Our Ref: SYD15/00301 (A10083768)
Your Ref: SSD 6954

**ENVIRONMENTAL IMPACT STATEMENTS (EIS) FOR IKEA MULTI-FUNCTION LOGISTIC
MARSDEN PARK, BLACKTOWN LGA (SSD 6954)**

Client	FDC BUILDING
Project	IKEA MFLU
	MARSDEN PARK INDUSTRIAL PRECINCT
	DEVELOPMENT APPLICATION
Title	CIVIL WORKS PLAN
	SHEET 1

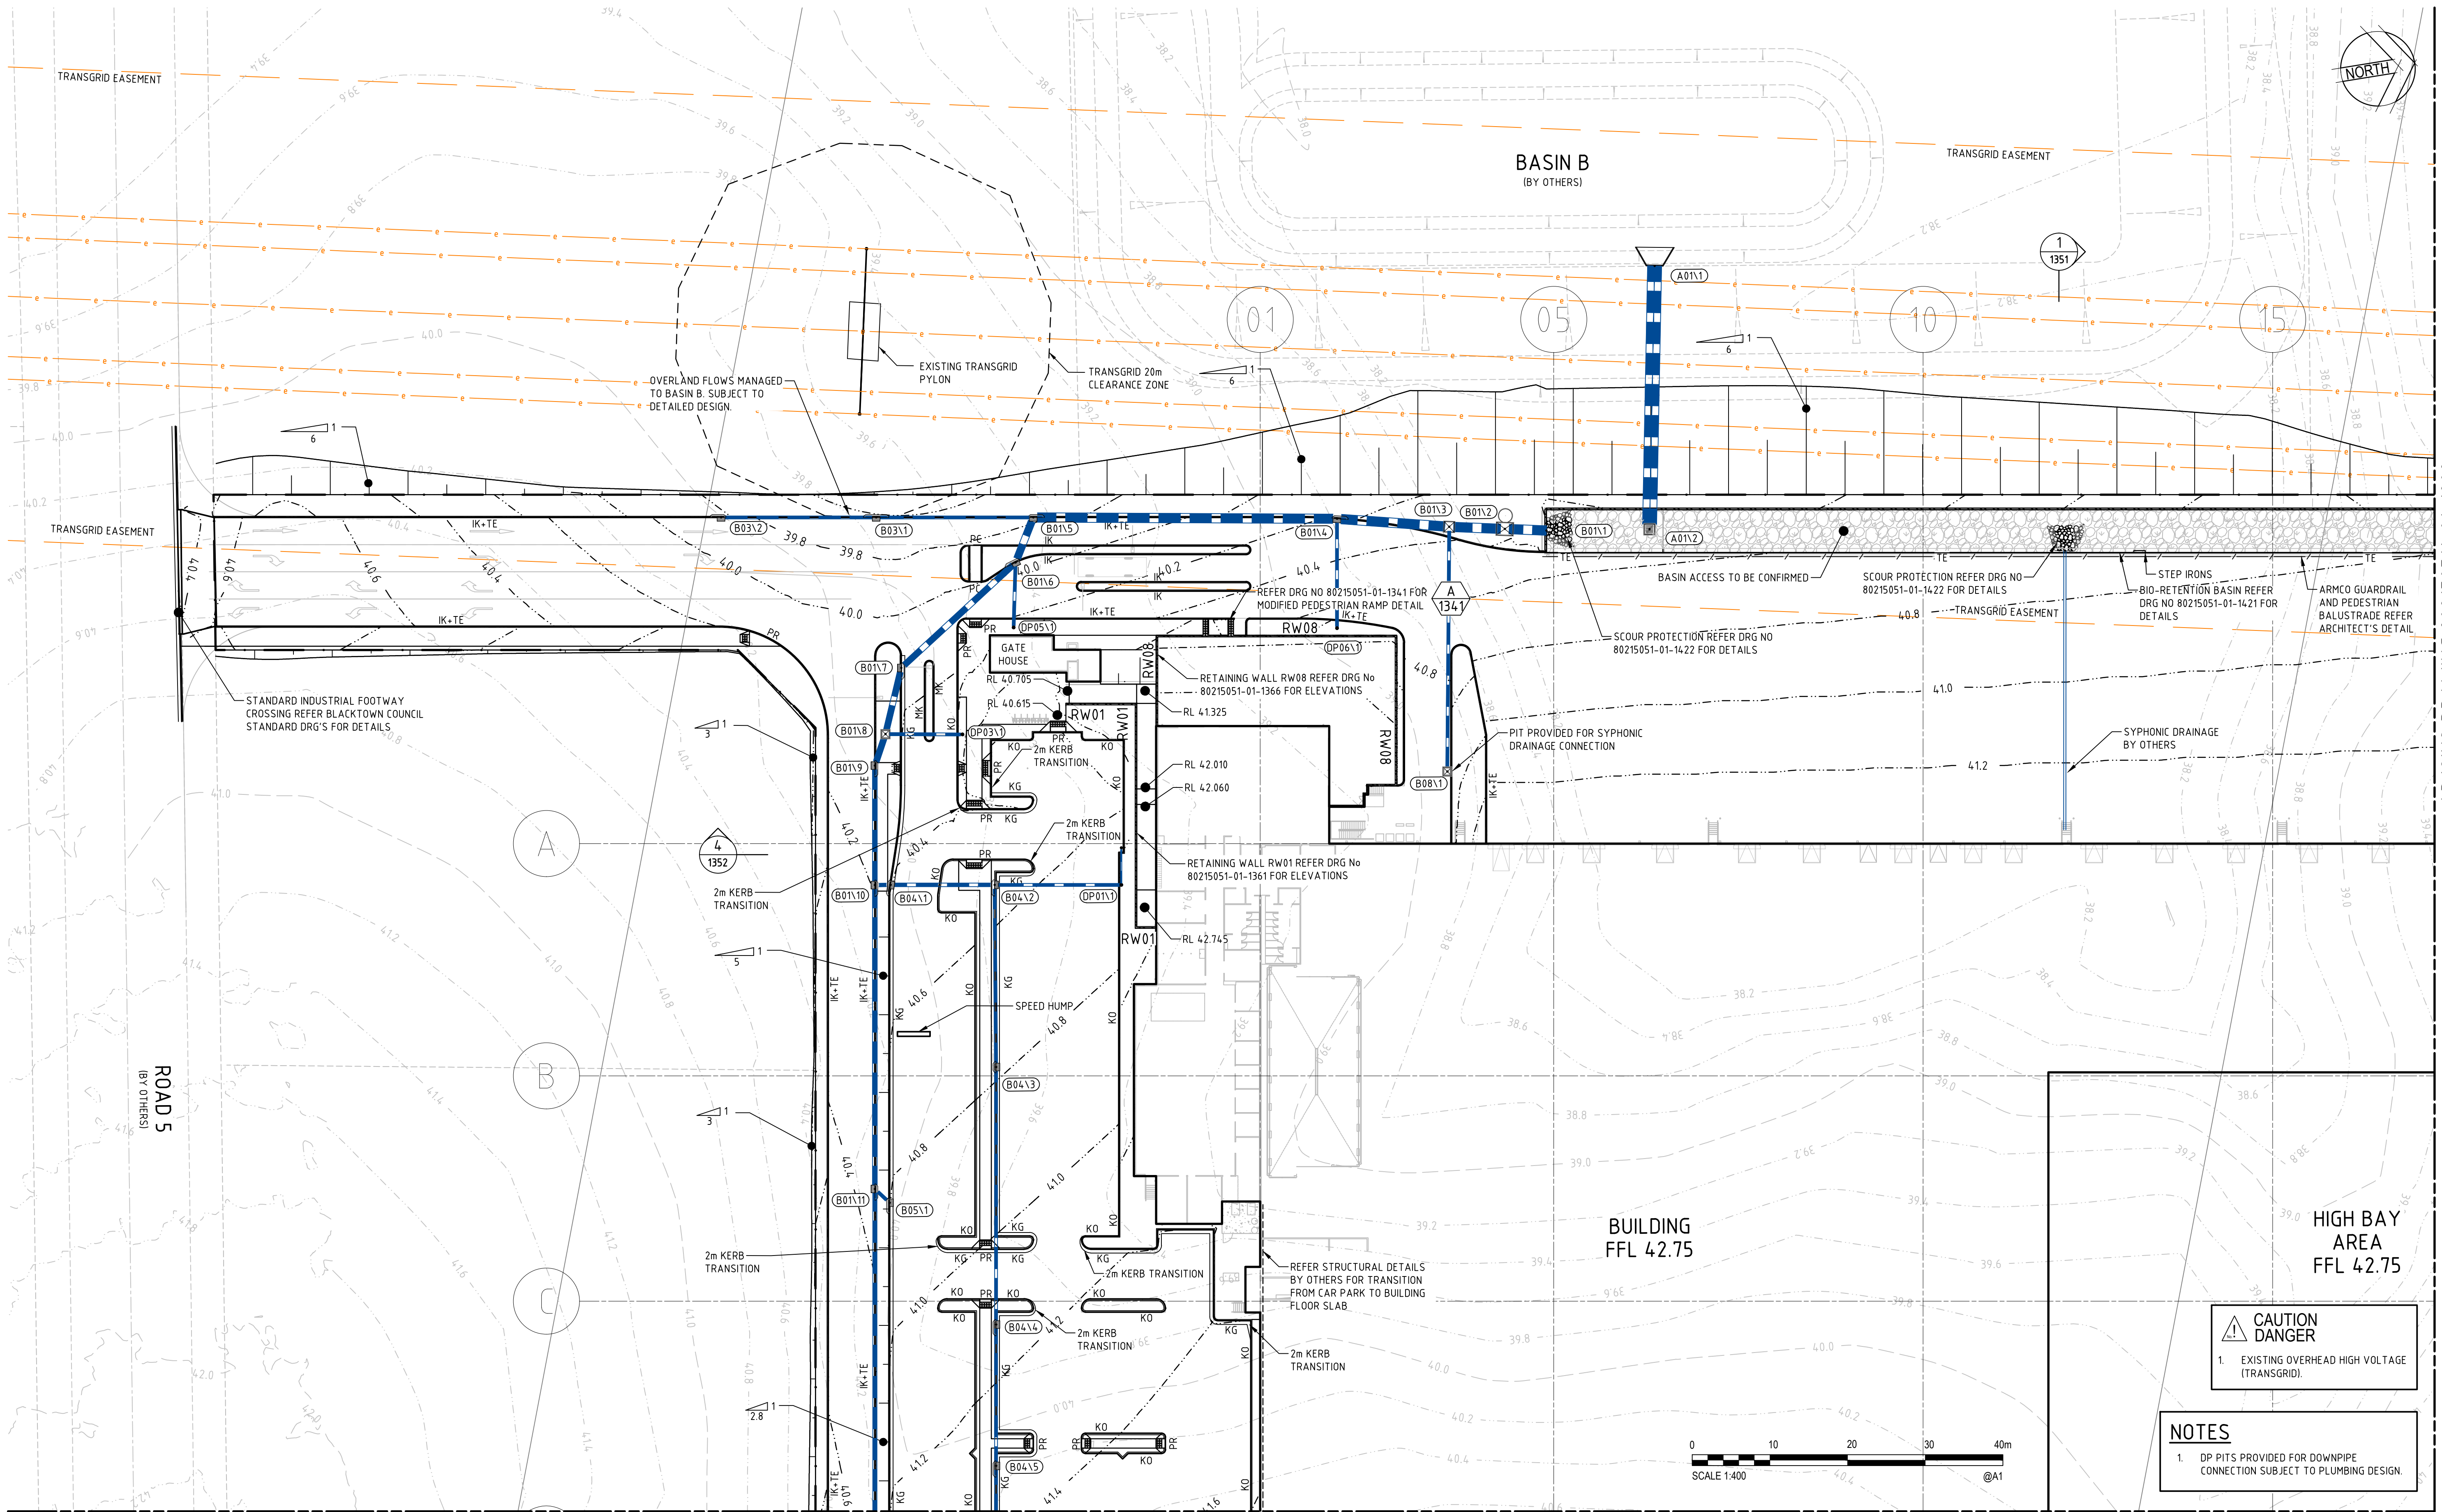
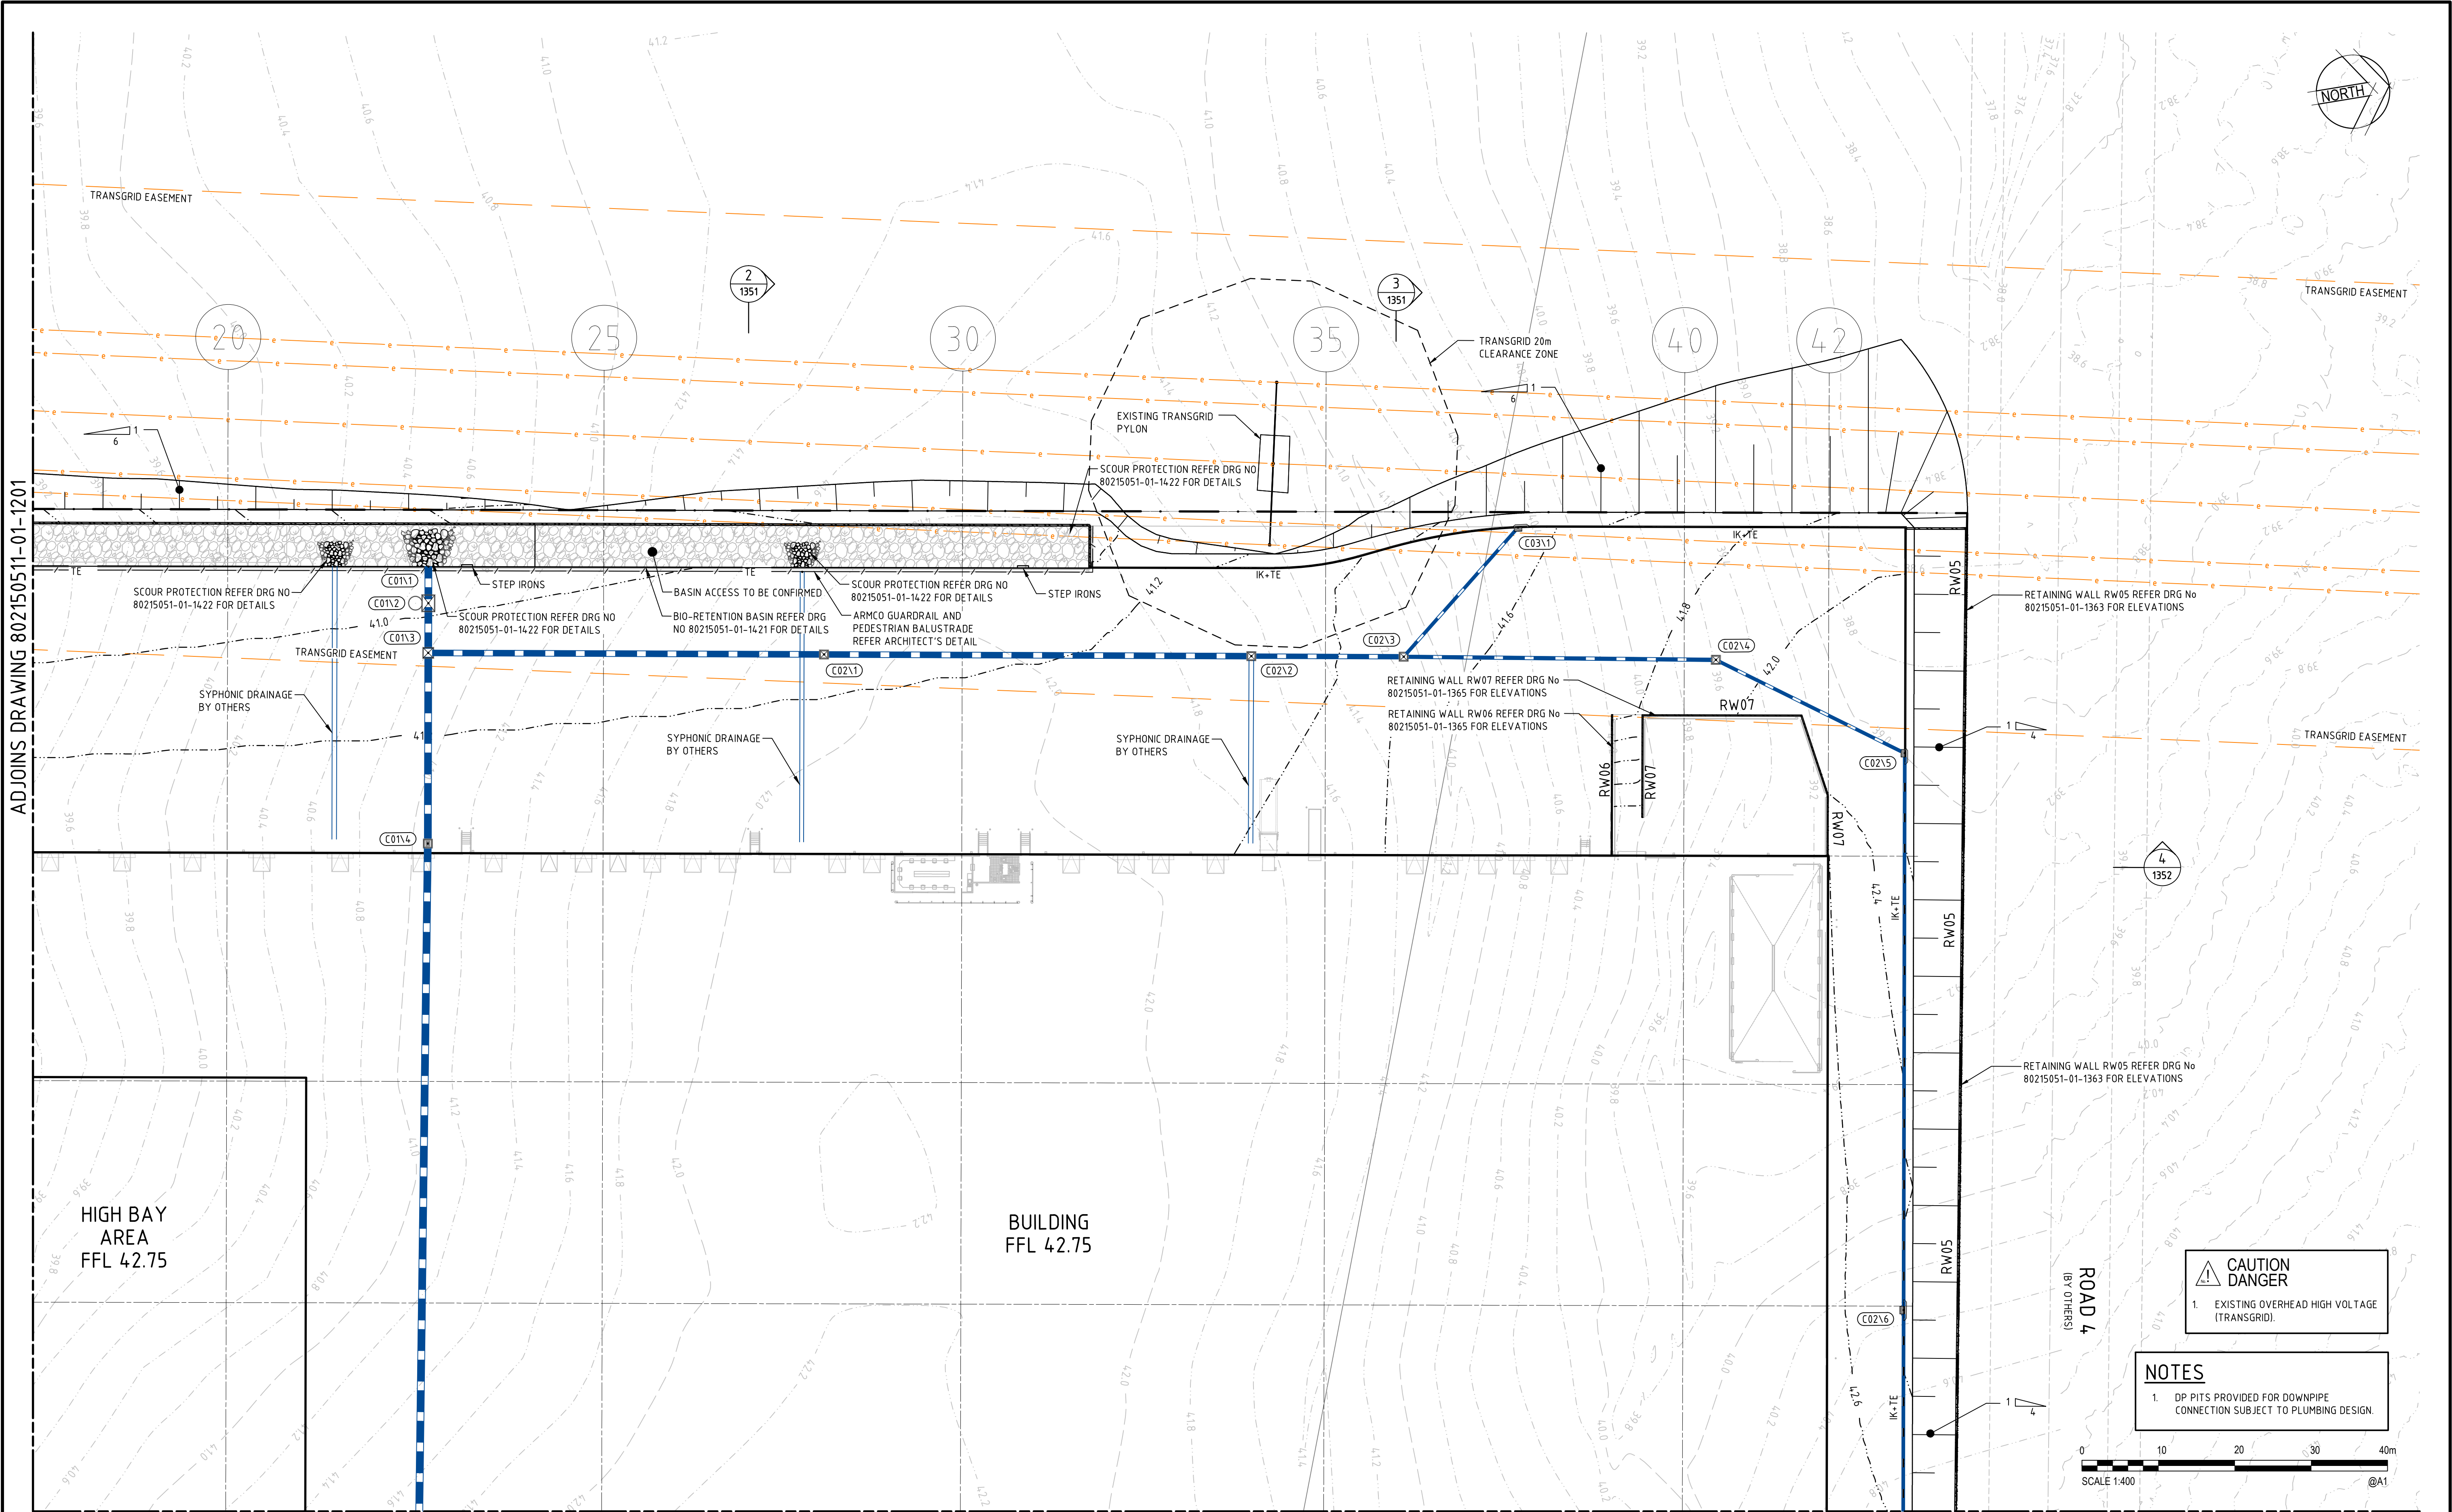
Roads and Maritime has reviewed the submitted application and raise no objection to the development proposal subject to the civil drawings being amended to reflect the updated access arrangements of all vehicles accessing the site from Richmond Road/Townson Road intersection.
